Lead Local Flood Authority

Date 09 May 2025

RE: F/15/24/RES – Land at Ford Airfield, Ford, West Sussex

We previously objected on 17 February 2025 on runoff rates, calculations, details of attenuation features, easement of 3m for watercourse and phasing plans.

Drawing Title:
**FORD LANE ROUNDABOUT
CONSTRUCTION DETAILS (SHEET 2 OF 3)**

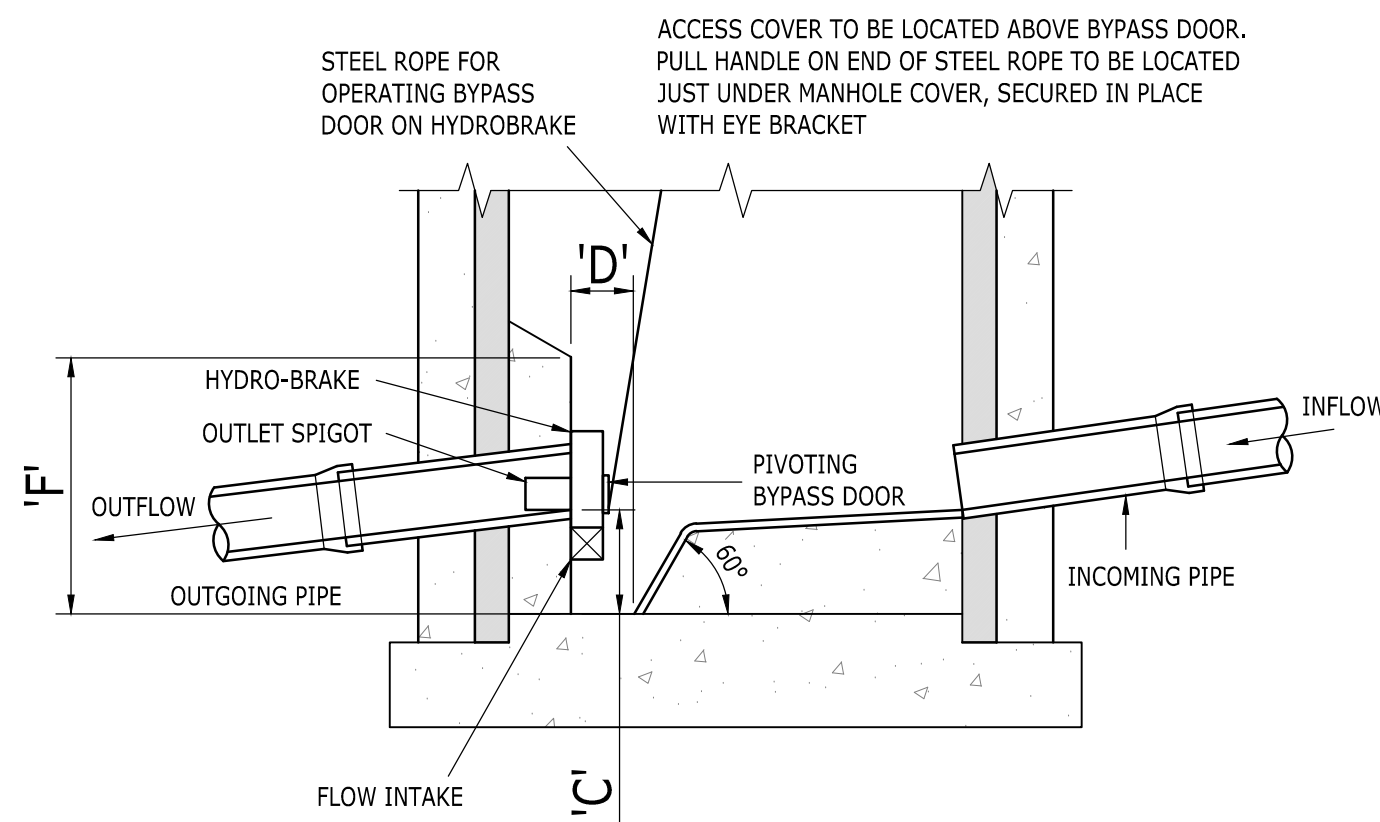
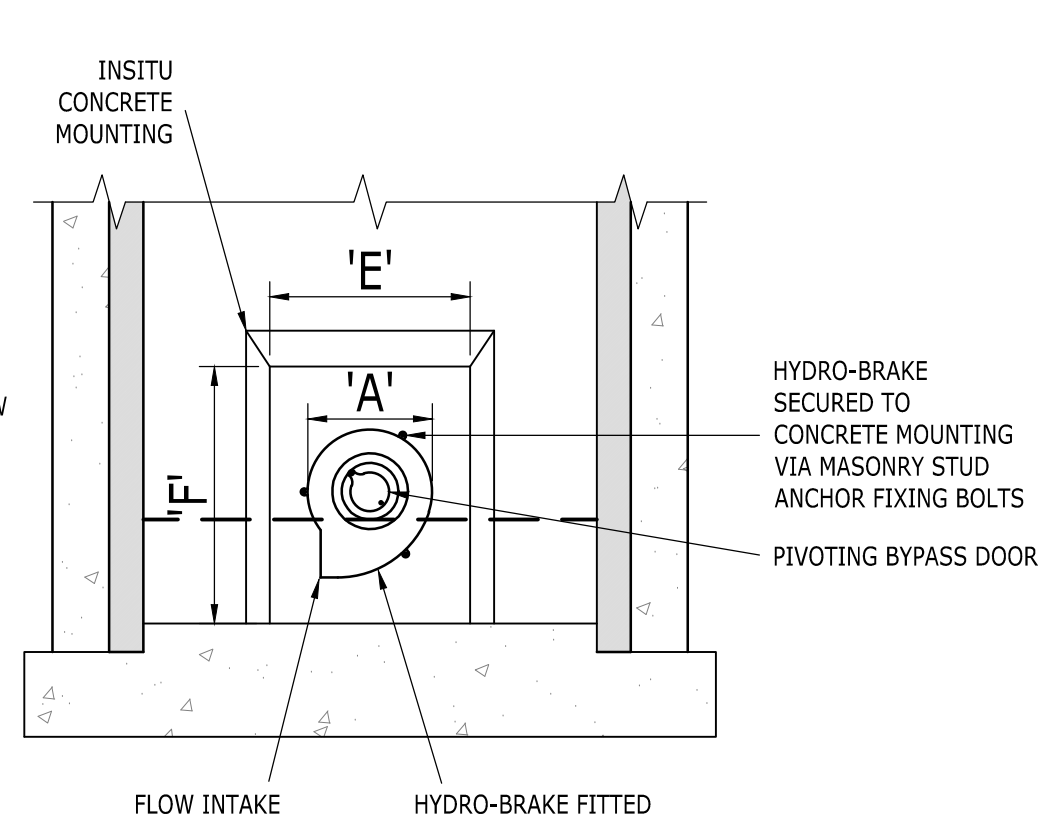
In relation to **Point 3**, we are satisfied the response submitted by Ardent (dated 02 December 2024, REF CC/2205771) confirms that the discharge rate for the site will be controlled to Qbar (13 l/s) and see the drawings have been updated accordingly therefore **remove our objection in principle** to this matter.
